CHENNAI METROPOLITAN DEVELOPMENT AUTHORITY
Thalamuthu Natarajan Building, No.1, Gandhi Irwin Road, Egmore.
Chennai - 600 008
Phone : 28414855 Fax: 91-044-28548416
E-mail: mscmda@tn.gov.in, Web site: www.cmdachennai.gov.in

Letter No.PP/SB/C/ 116 /2019, Dated: 22.05.2019

Sub: CMDA – Area Plans Unit - ‘B’ Channel (Central) - Planning Permission for the proposed construction of Ground floor + 4 floors Residential building with 143 dwelling units and 2 Nos. of Shops in Ground floor (92.07 sq.m) at S.No. 352/2B2 of Thirunindarvur village within the limit of Thirunindarvur Town Panchayat – Remittance of DC & Other charges – DC advice Sent – Reg.

SITE CUM GROUND FLOOR PLAN

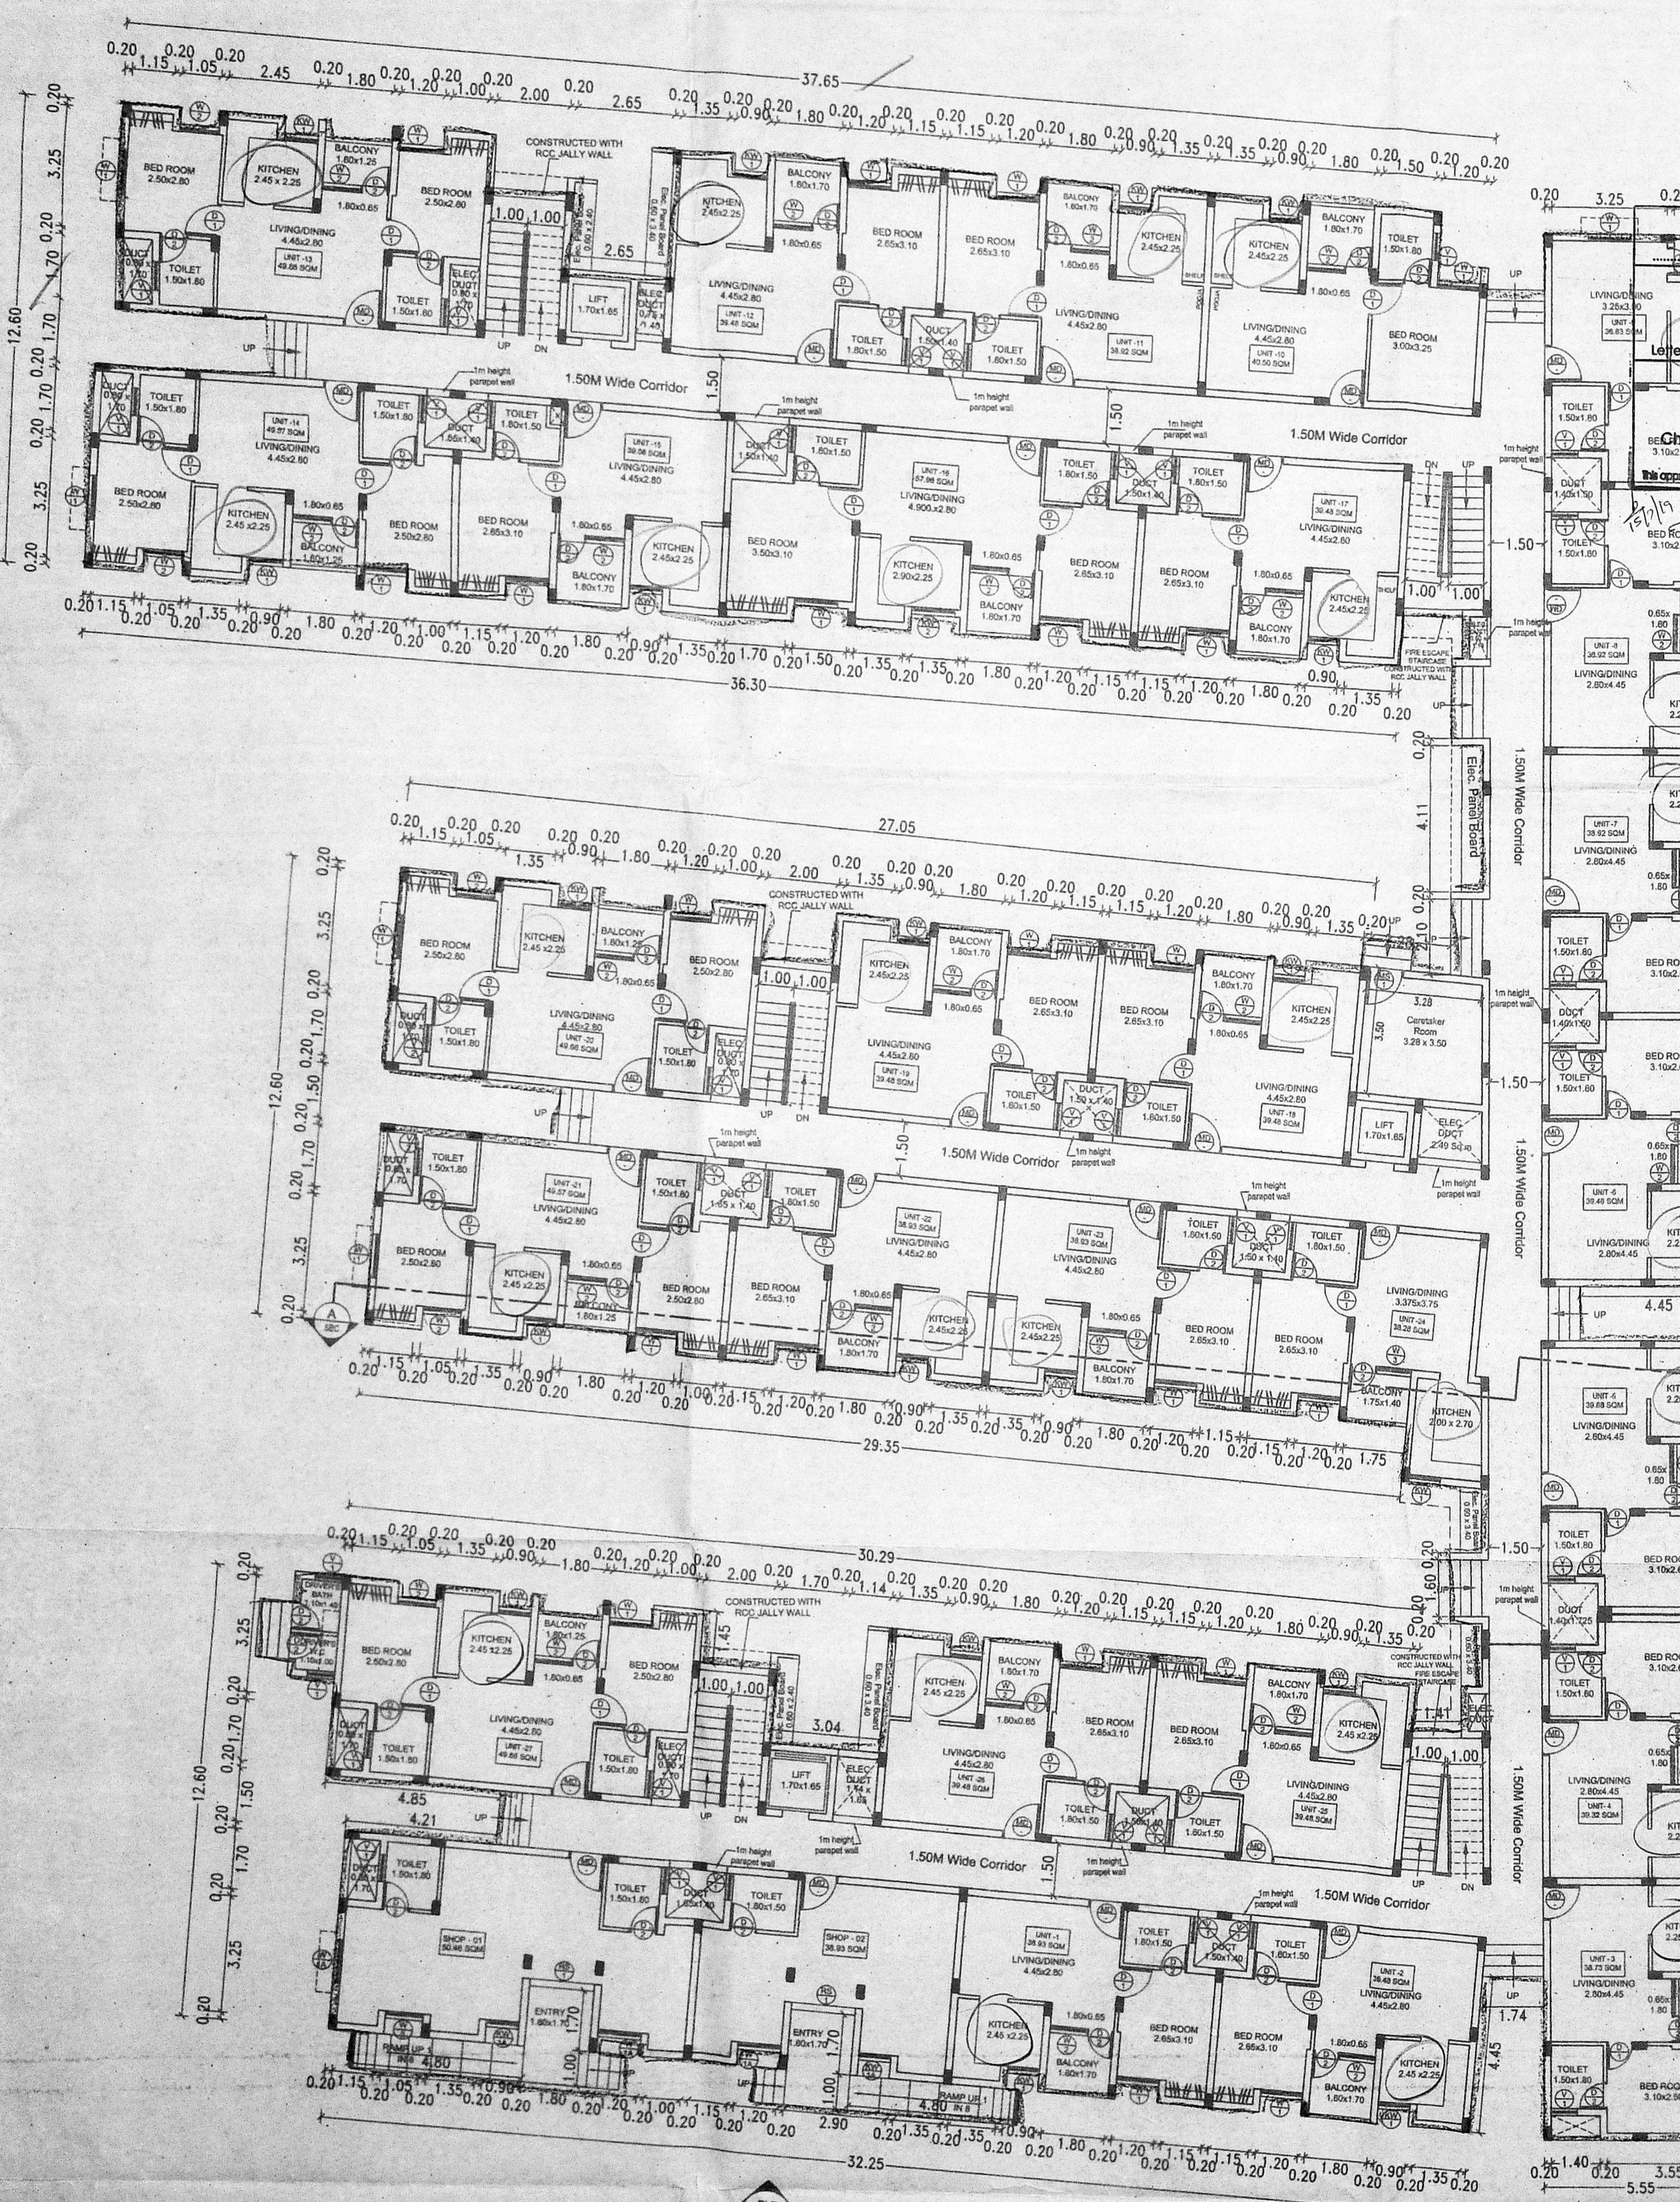
2. Form B & C as per format prescribed in the TNCDBR to be furnished.
 3. Road widening portion and OSR portion to be gifted to CMDA and the gift deed document details to be shown in the plan.

6. Setback details to be shown correctly.
 7. Solar energy capture provisions to be shown as per TNCDBR.
 8. Title and Area statement to be shown correctly.

DRAWING TITLE :
GROUND FLOOR PLAN & FIRST FLOOR PLAN

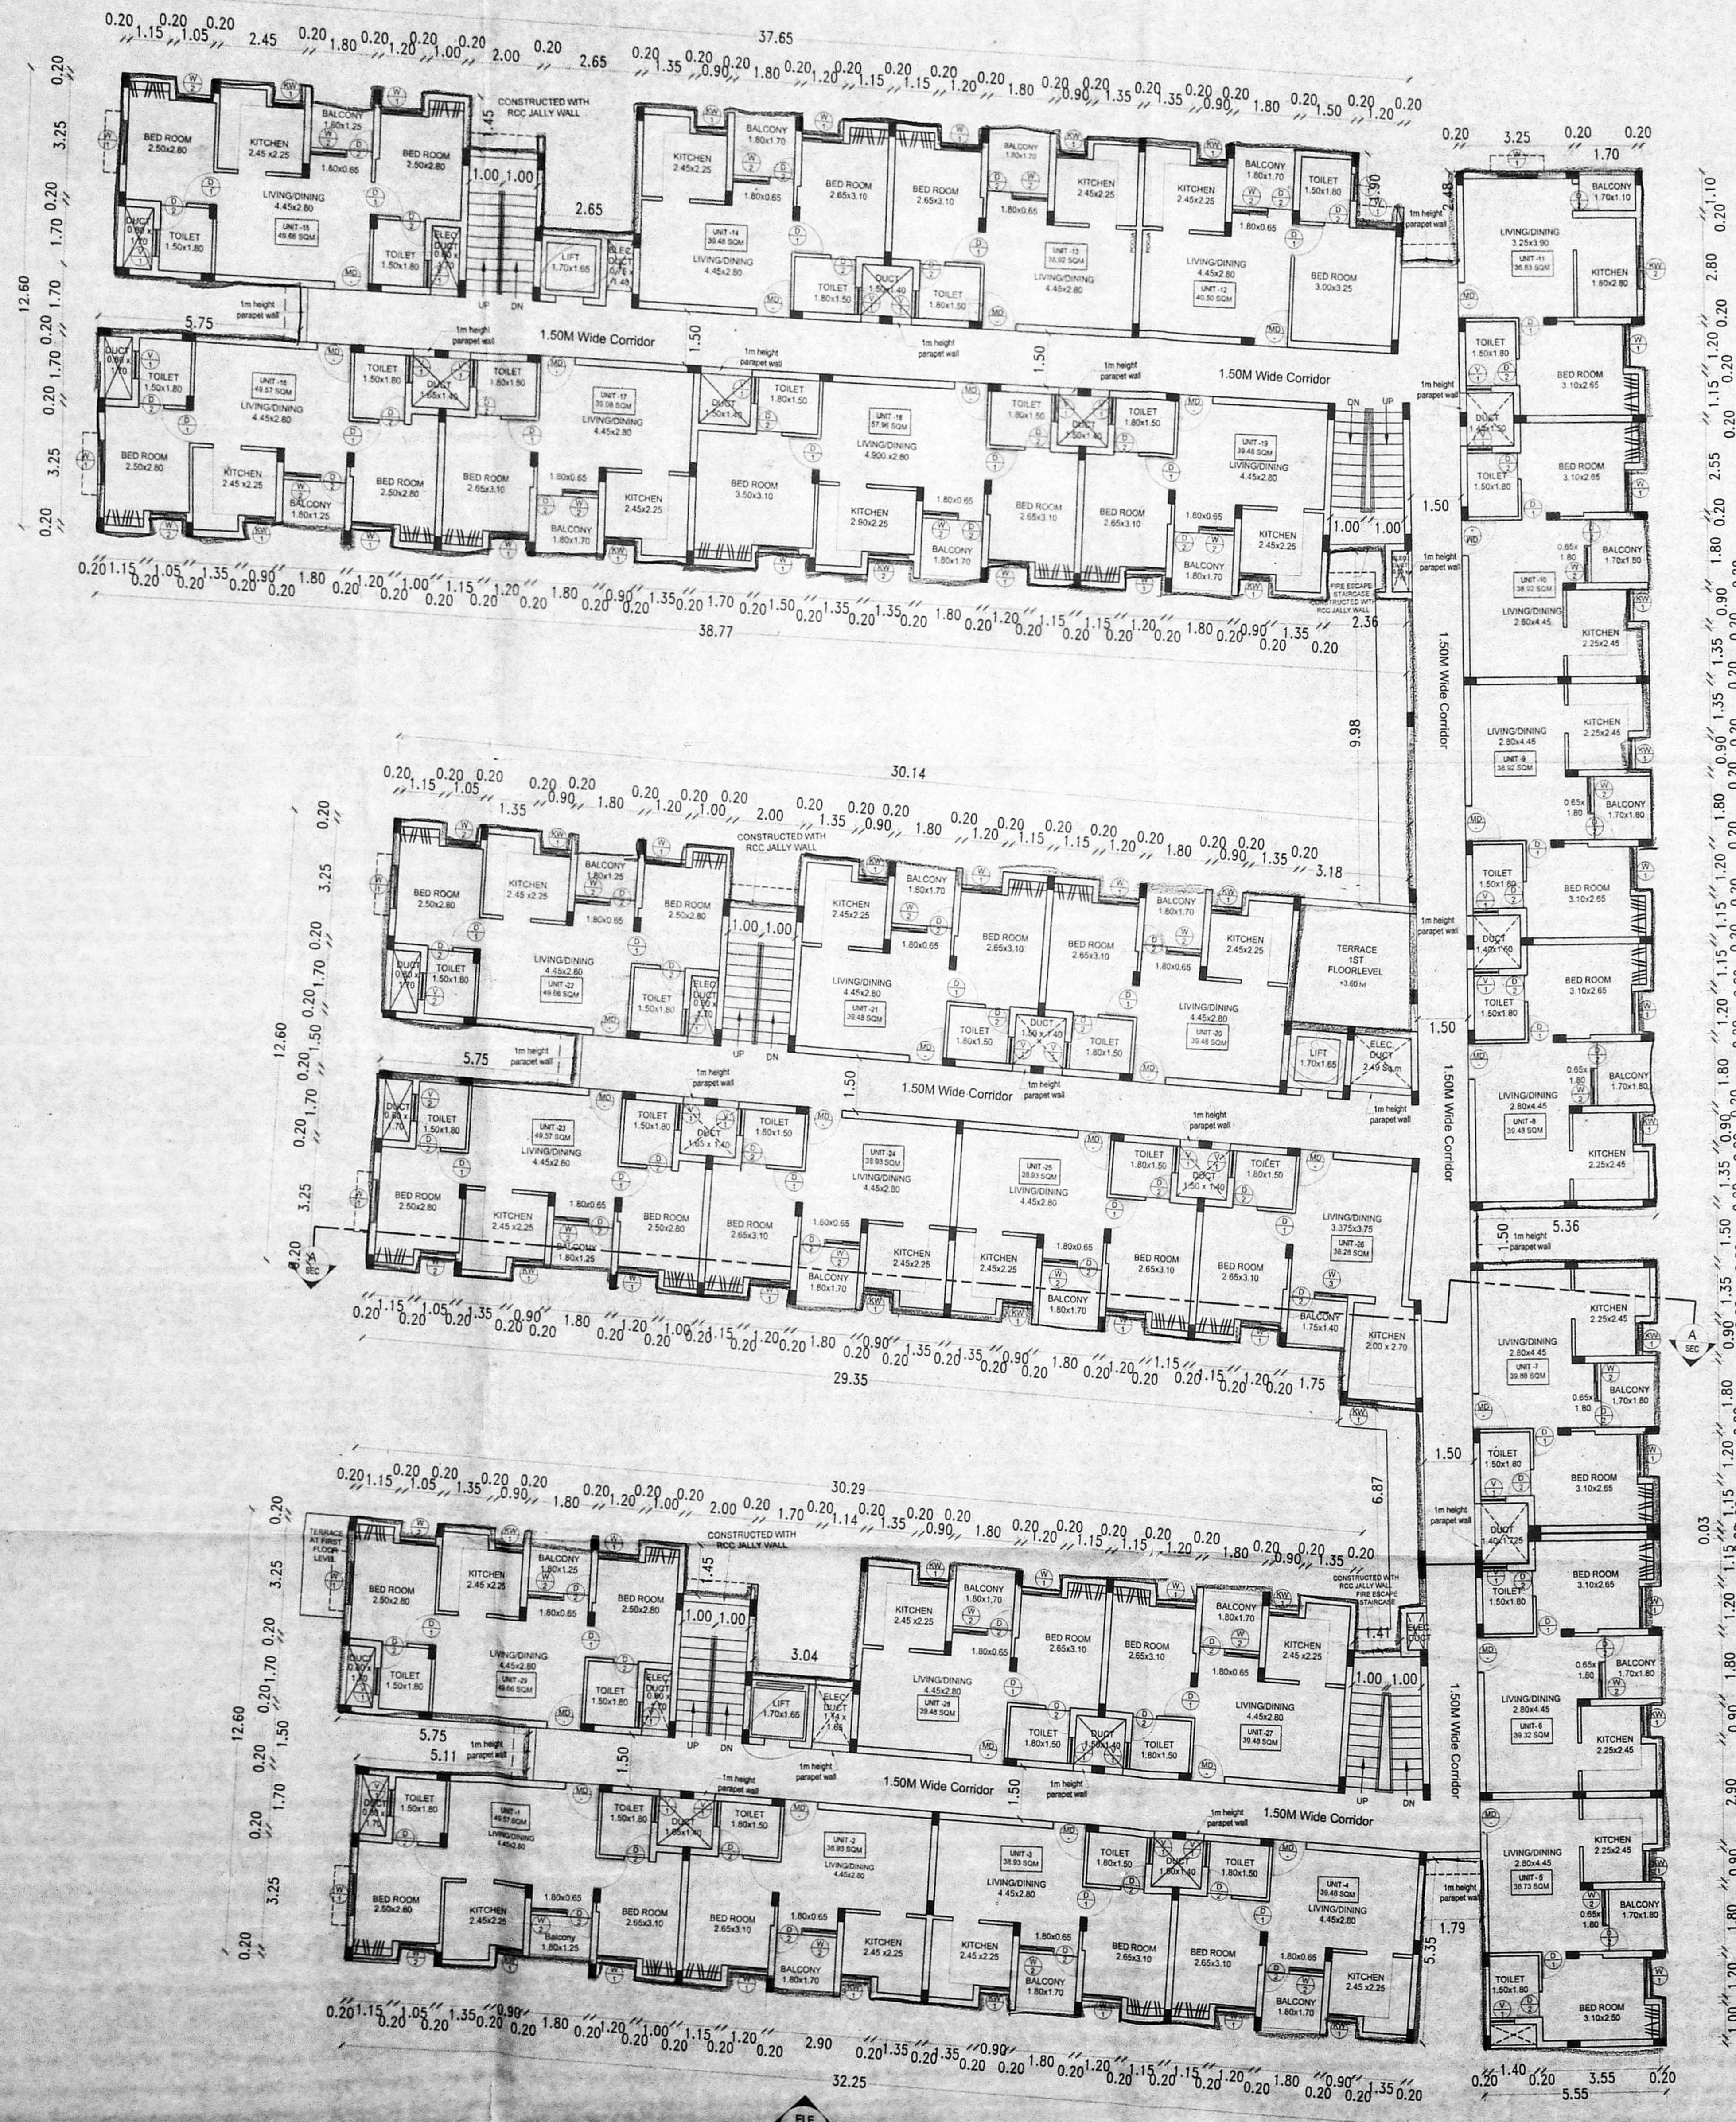
- X 11. The door from Living room to open terrace at 1st floor to be closed.
 12. NOC obtained from PWD to be furnished.
 13. Ramp to be provided for PCP (shop)

14. Steps to be provided for caretaker room.
 15. GL to be shown correctly in section & elevation plan.

TERRACE FLOOR PLAN

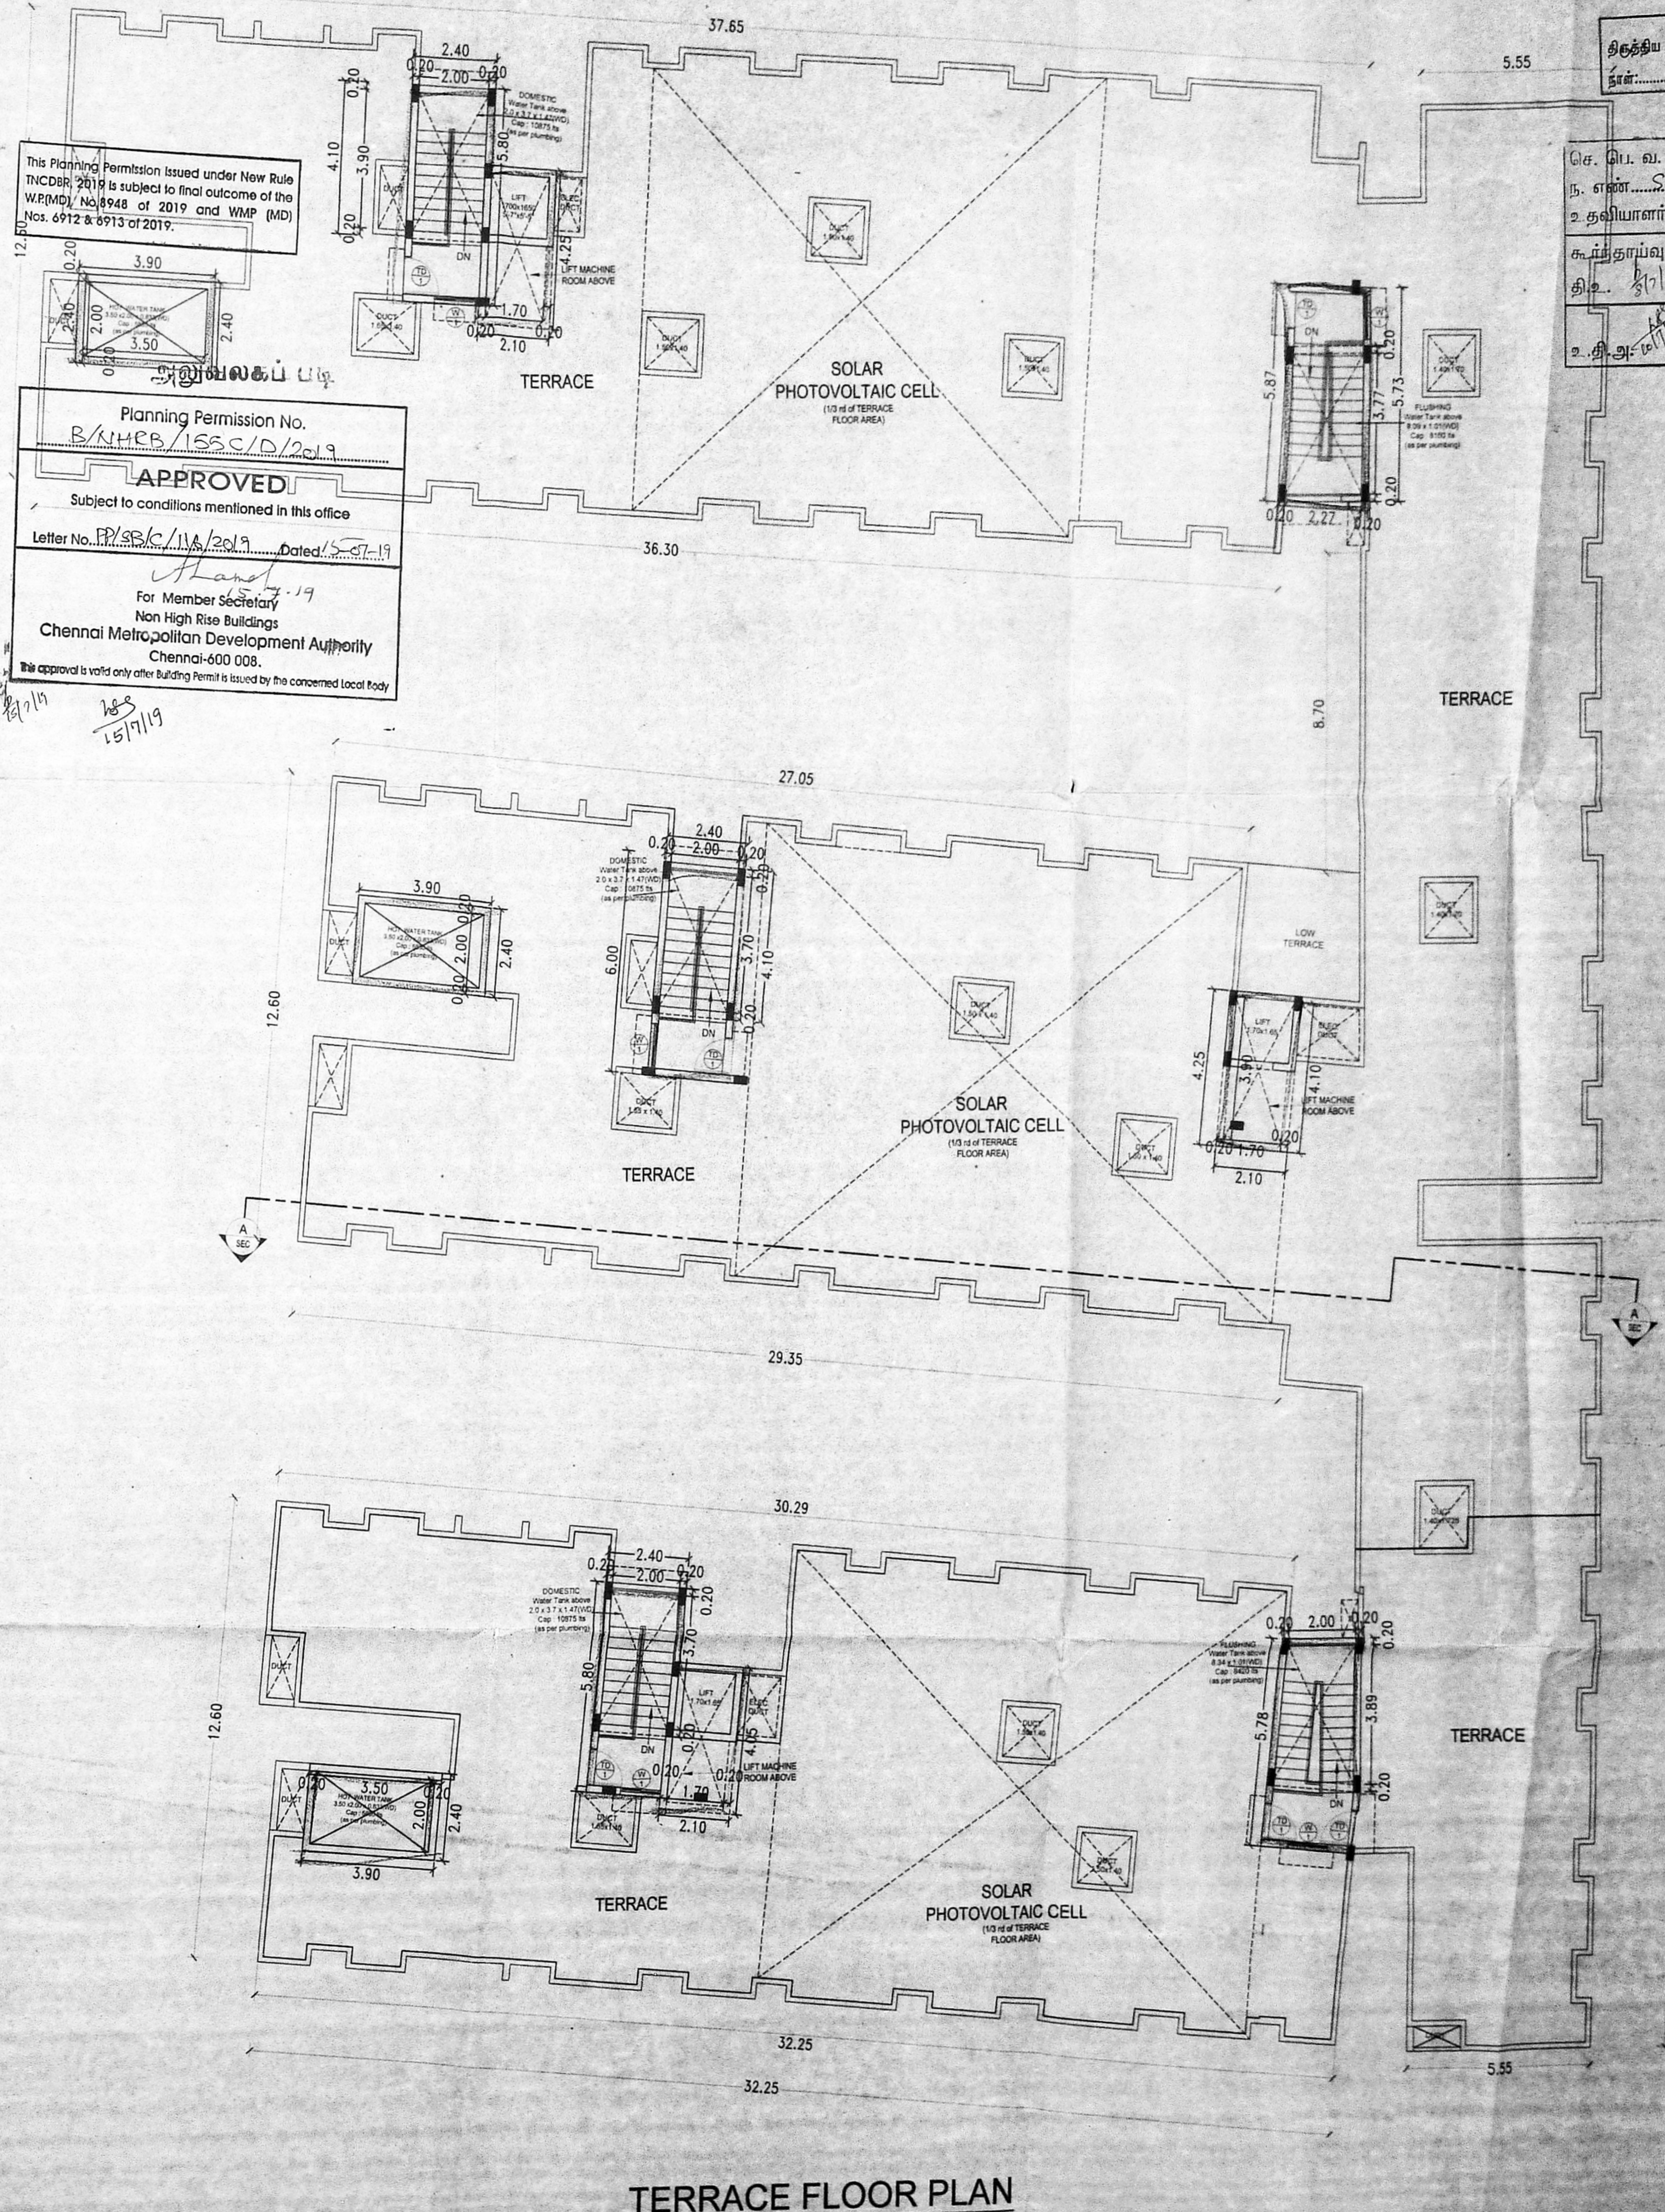
- X 9. STP design as obtained from Registered consultant to be incorporated in the plan.
 10. OHT, LMR, Head room measurement to be shown in terrace floor.
